Rosefield Solar Farm

Schedule of Changes to the draft DCO ([Tracked](#))

EN010158/APP/[3.1.78-1.6](#)
Revision [076](#)
Deadline [54](#)
[June/July](#) 2026
Rosefield Energyfarm Limited

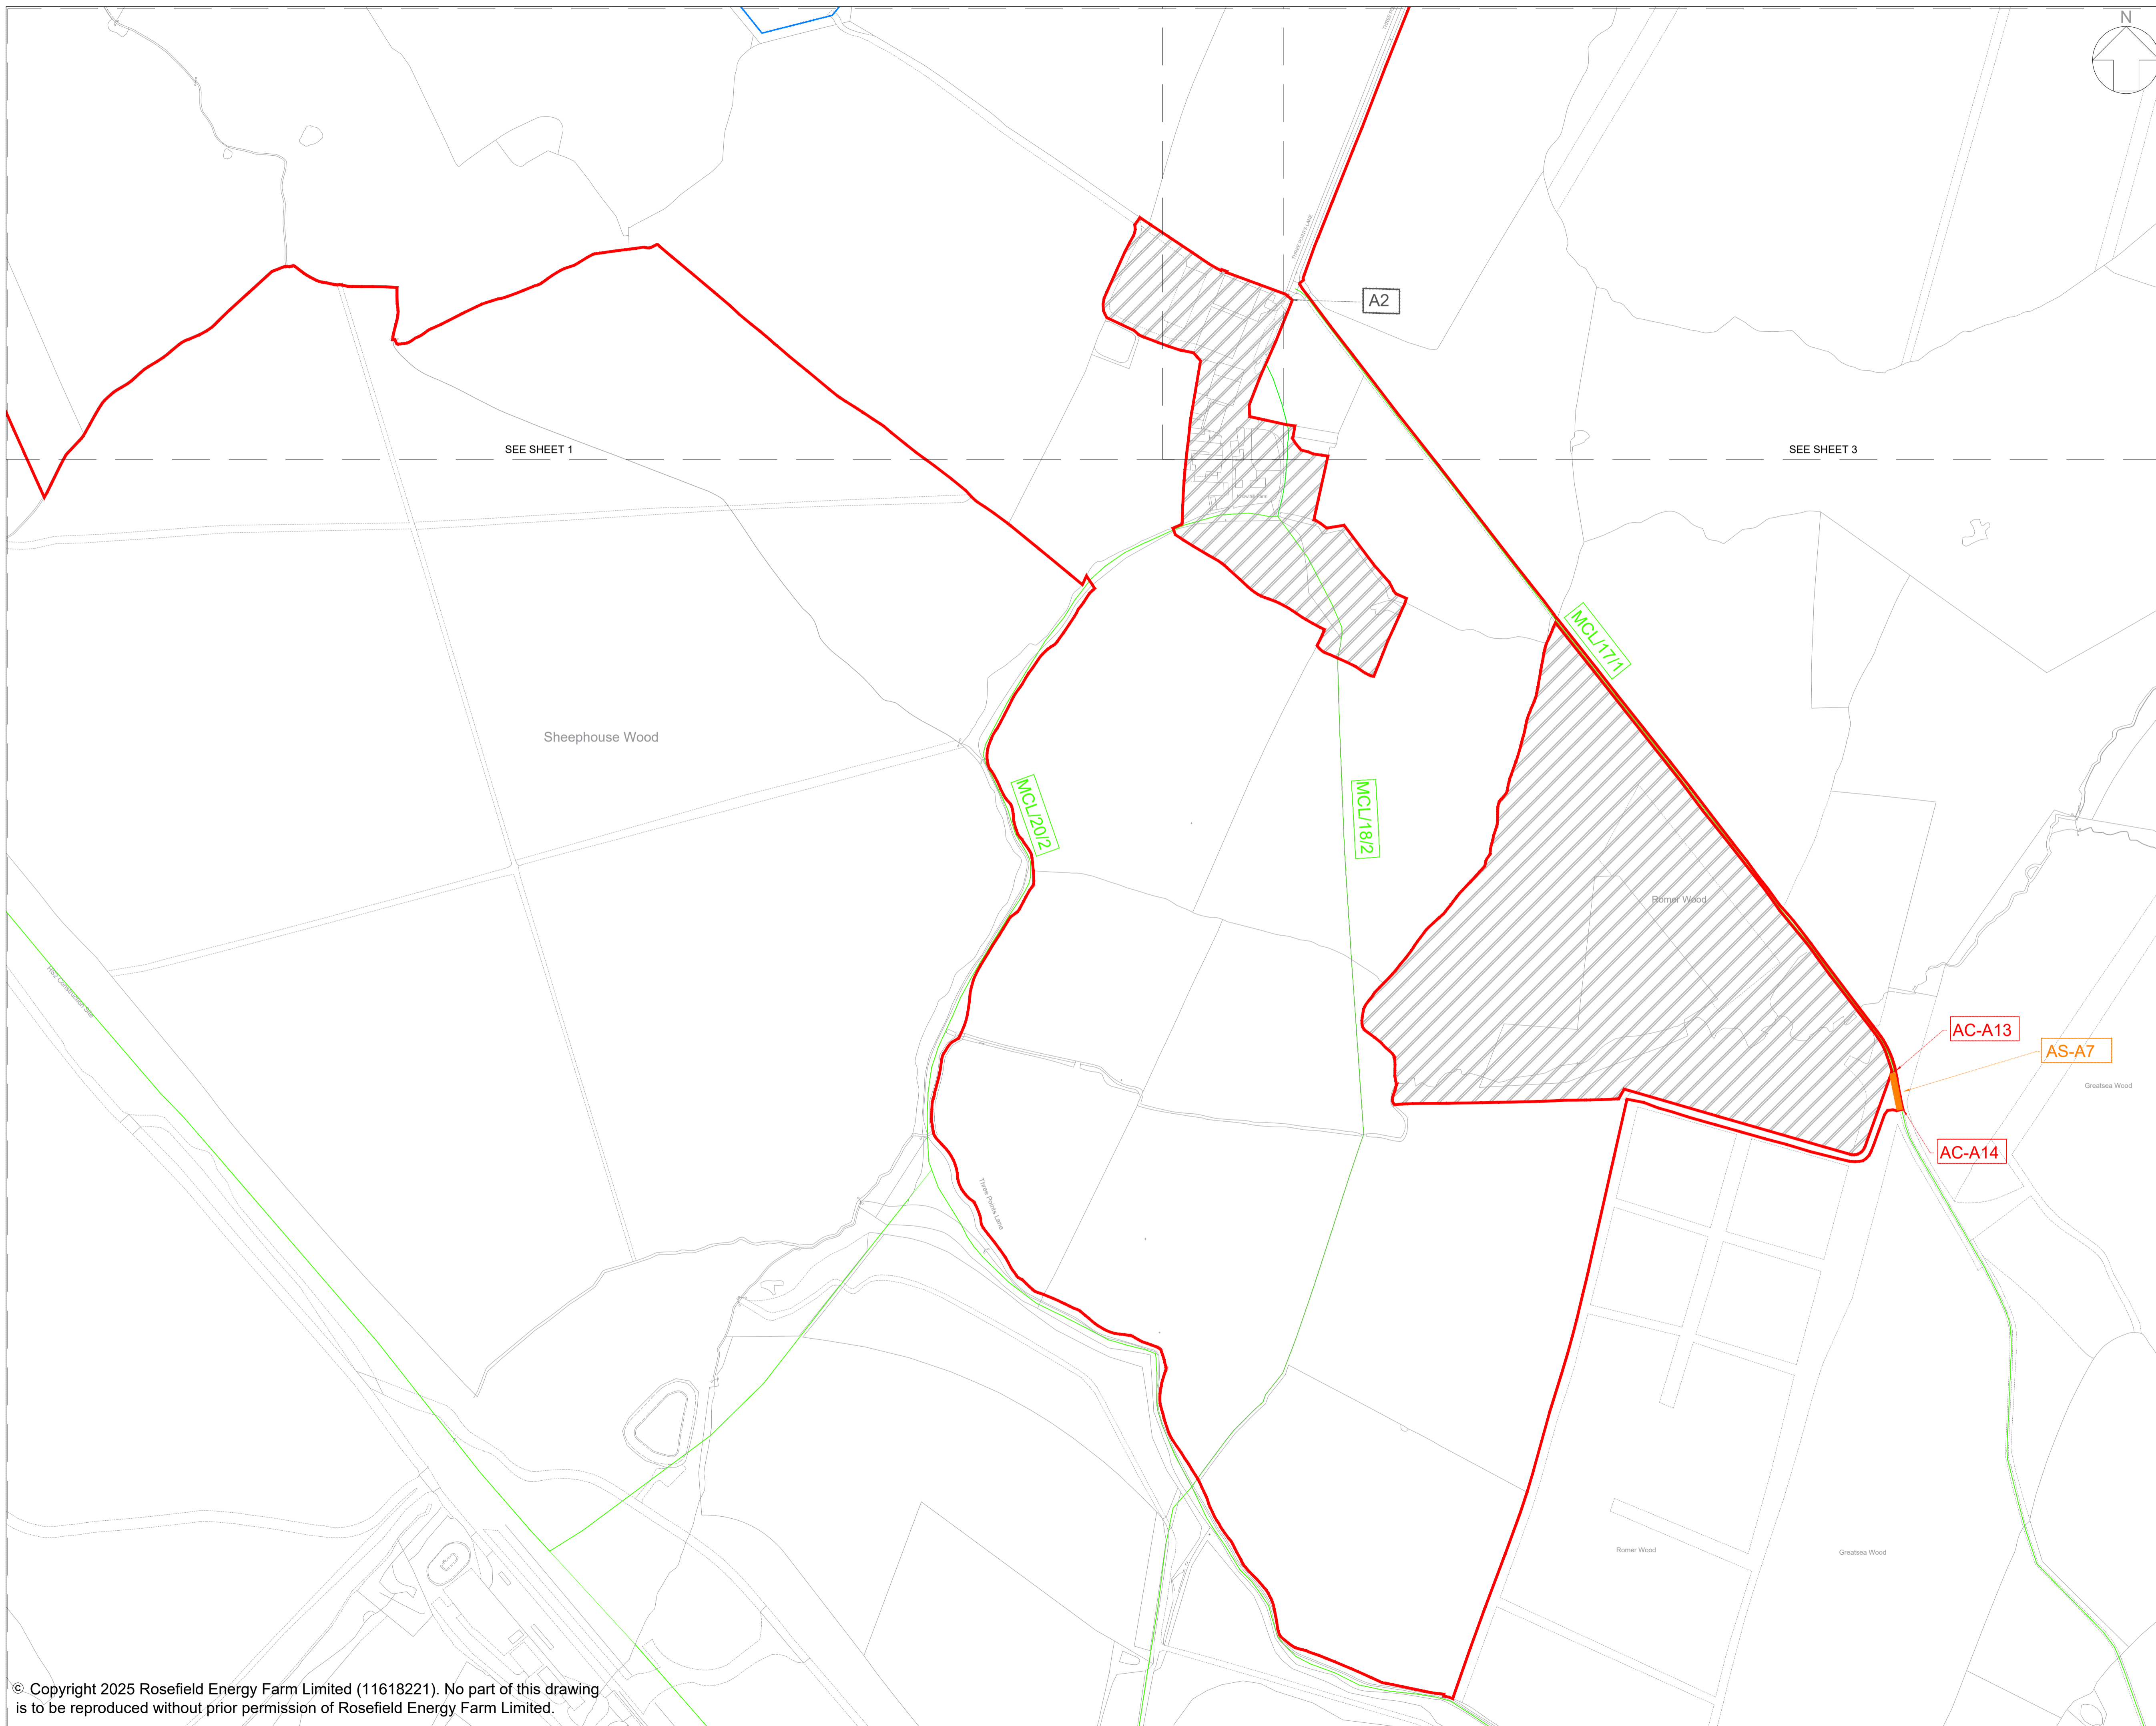
<table><tr> <th>(1) <i>Area</i></th><th>(2) <i>Public right of way to be stopped up</i></th><th>(3) <i>Extent of stopping up</i></th><th>(4) <i>New public right of way to be substituted / provided</i></th></tr><tr> <td>District of Buckinghamshire</td><td>SCL/13/1 and SCL/13/2</td><td>For a distance of 1,210 metres between points PE-A7 and PE-A3 as shown on sheet 1 of the streets, access and rights of way plans.</td><td>New public footpath of minimum width of 2m to be provided between points PE-A7, PE-A5 and PE-A4 and PE-A3 as shown by a cyan line on sheet 1 of the streets, rights of way and access plans.</td></tr><tr> <td>District of Buckinghamshire</td><td>SCL/12/2</td><td>For a distance of 190 metres between points PE-A7 and point PE-A10 as shown on sheet 1 of the streets, access and rights of way plans.</td><td>New public footpath of minimum width of 2m to be provided between points PE-A7, PE-A5 and its intersection with SCL/12/1 as shown by a cyan line on sheet 1 of the streets, rights of way and access plans.</td></tr></table>
